**WELWYN HATFIELD BOROUGH COUNCIL
EXECUTIVE DIRECTOR - PLANNING, PUBLIC PROTECTION AND GOVERNANCE**

DELEGATED APPLICATION

Application No: 6/2020/1745/HOUSE
Location: 6 Hill Rise Cuffley Potters Bar EN6 4EE
Proposal: Erection of first floor front extension, alteration of roof form into crown roof, part single part two storey rear extension, alteration of fenestration and insertion of first floor side windows into the western flank elevation wall.
Officer: Mr Antoine Commenville

Recommendation: Granted

Drawing file: Document / Download

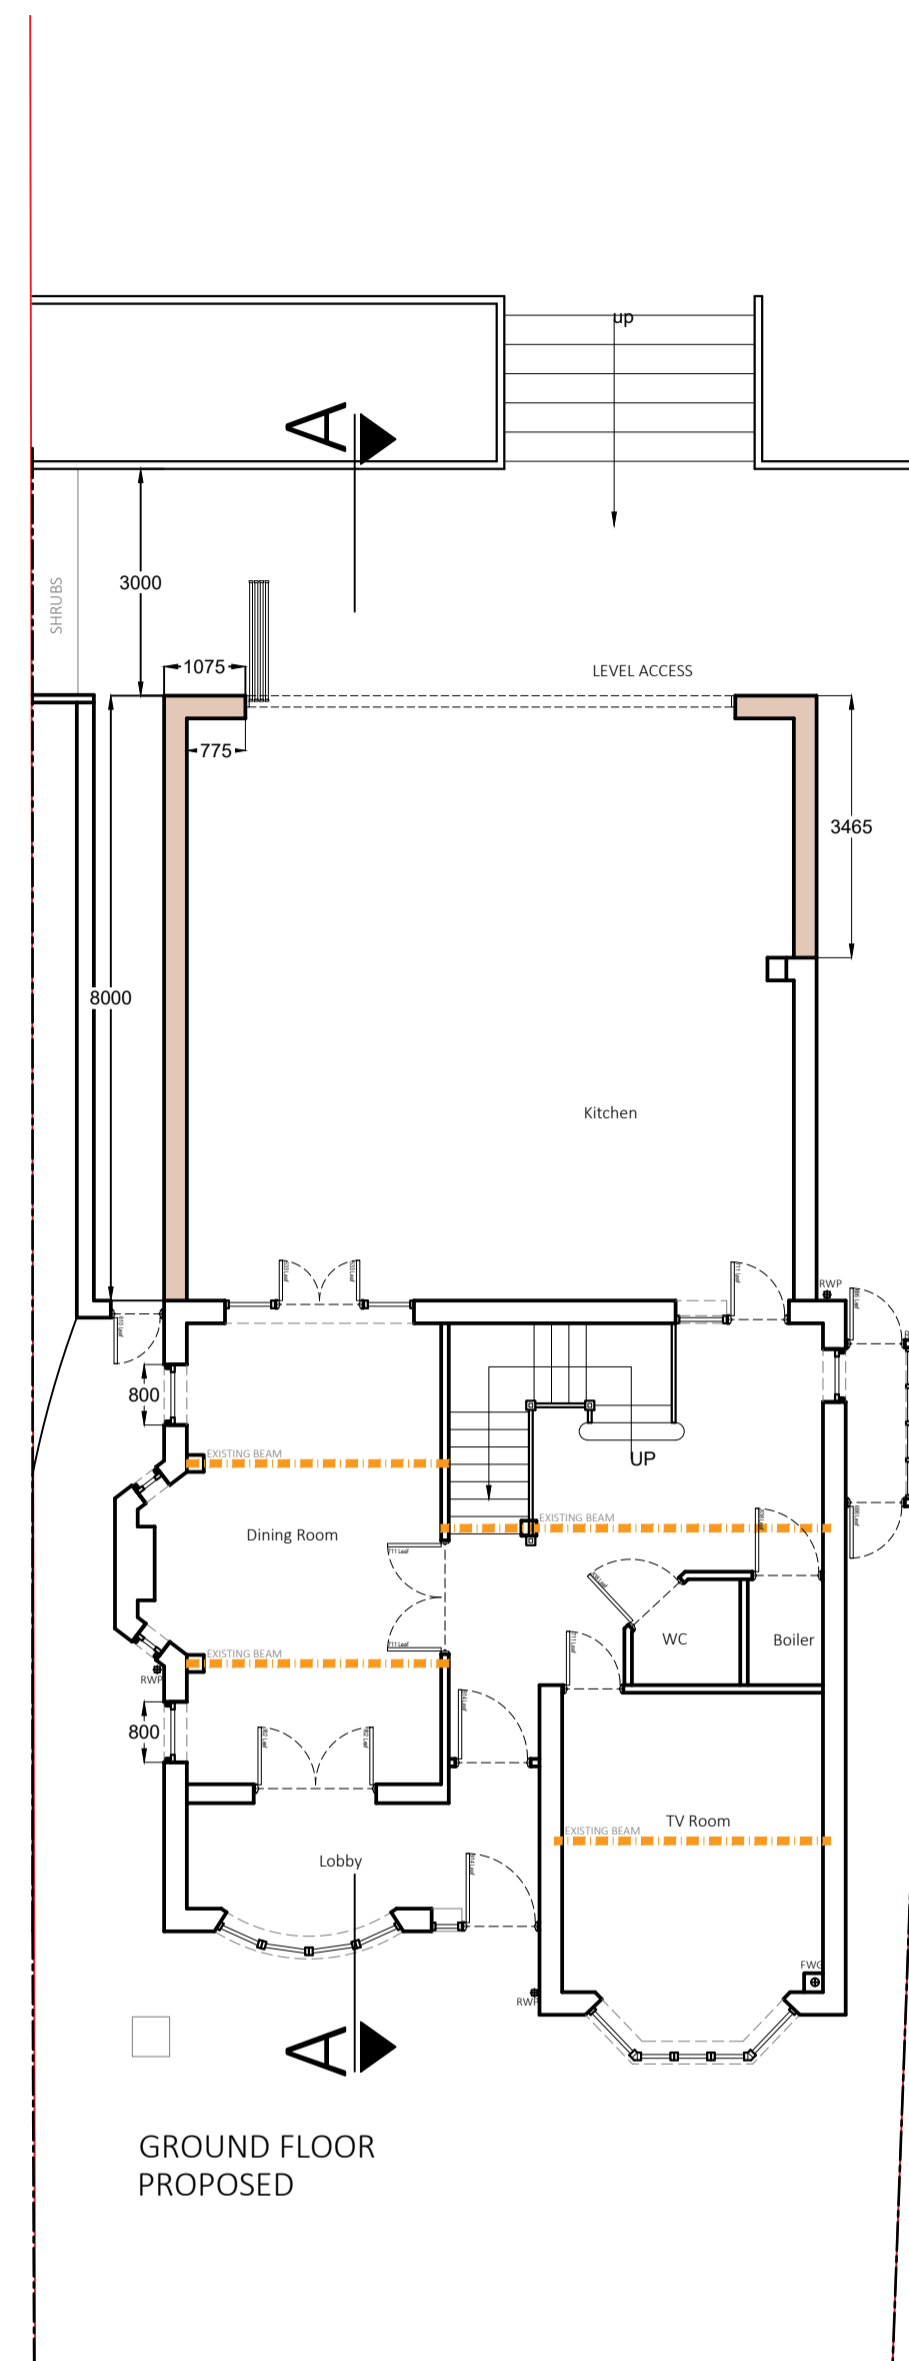
Comment (if applicable): A first floor flank window is proposed to be inserted within the western

flank elevation wall at first floor level and facing No.8. It is considered reasonable to add a condition for this window to be obscure glazed and non-opening below a height of 1.7 metres when measured from internal floor level to ensure that the windows would not result in any overlooking or a loss of privacy to No.8. However, this window is the only window serving this bedroom which is not ideal. However, this would be the only bedroom out of 4 proposed bedrooms to be served with obscured glazing only and it is therefore considered to be acceptable.

3. Any upper floor window located in a wall or roof slope forming a side elevation of the building hereby approved must be obscure-glazed and non-opening unless the parts of the window which can be opened are more than 1.7 metres above the floor

of the room in which the window is installed, and shall be retained in that form thereafter.
